From: David Fuller [REDACTED]
Sent: 22 January 2018 11:40
To: Anita Gardner
Subject: FW: LU/267/17/PL 2 flats Chilgrove House

TITLE
PROPOSED LAYOUT
AND ELEVATIONS
-

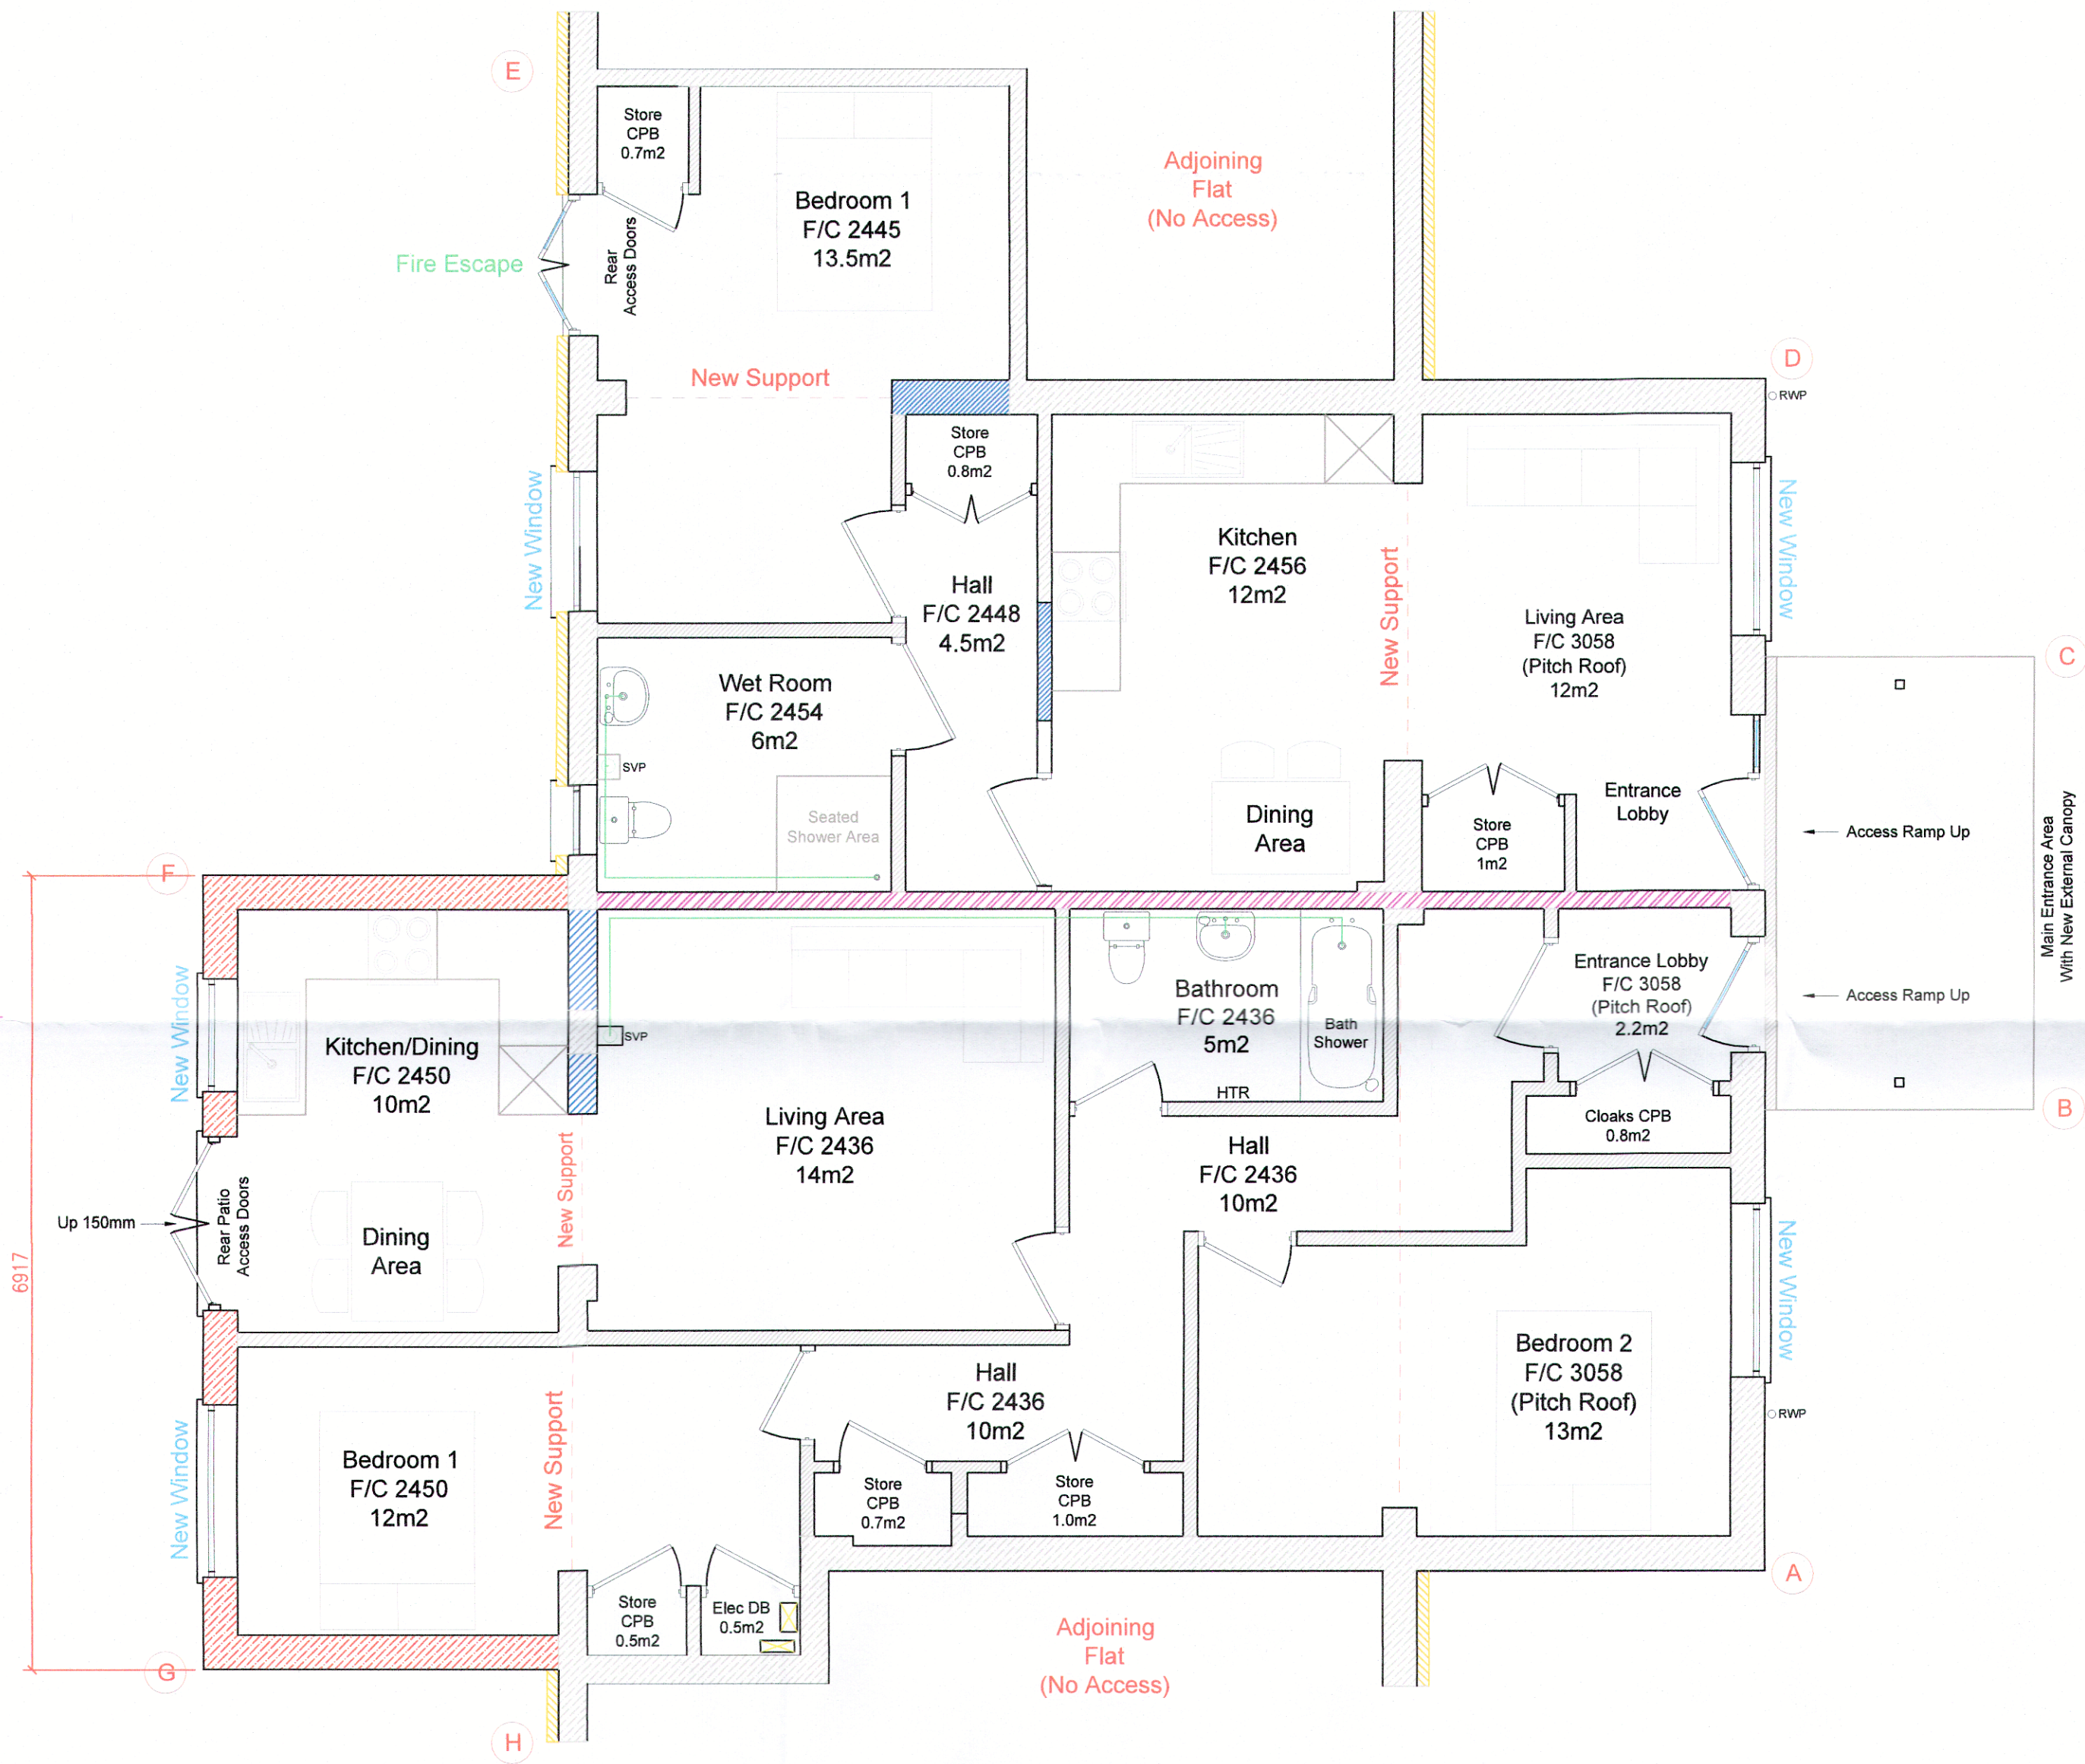
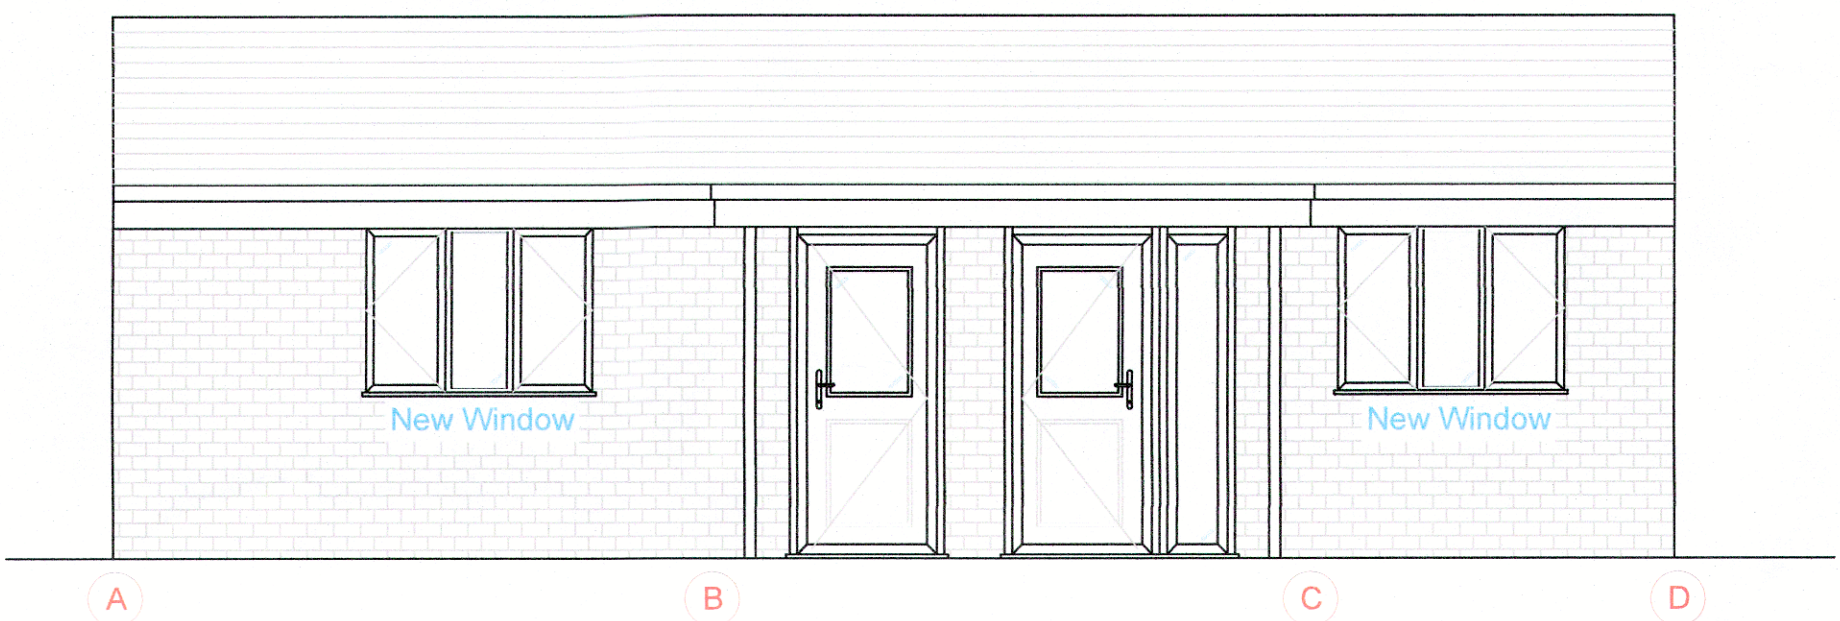
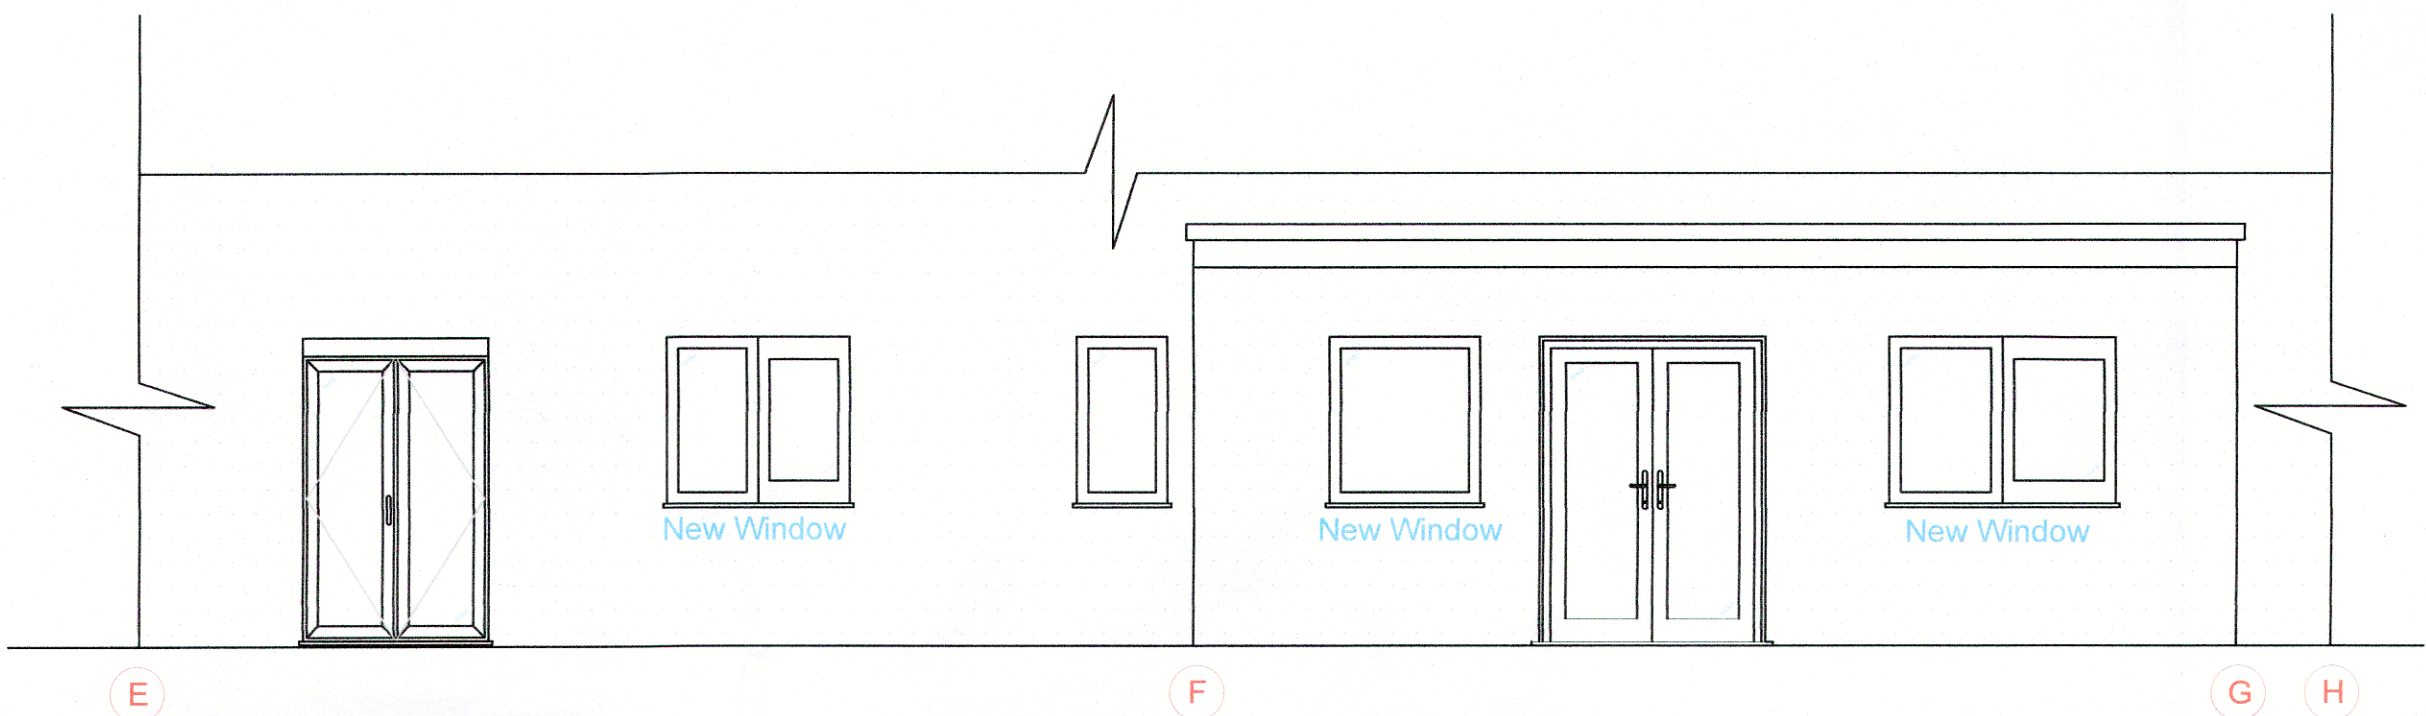
I also note that there are no side elevations of the extensions and these should be included with the additional information.

I need to be able to identify from floor plans and elevation plans the precise location of the rear extension in relation to the rooms both sides. The floor plan extract only shows one of the rooms adjacent to the proposed extension, that to the south, so that I cannot consider the impact of the extension on the residential amenity of both adjoining units including that to the north.

The elevation extract is insufficient to identify the precise position of the extension on the whole elevation. It is not clear where on the rear elevation it would be located. I would like to see it either superimposed on a photo or on an elevation showing the whole of the northern portion of the rear eastern elevation.
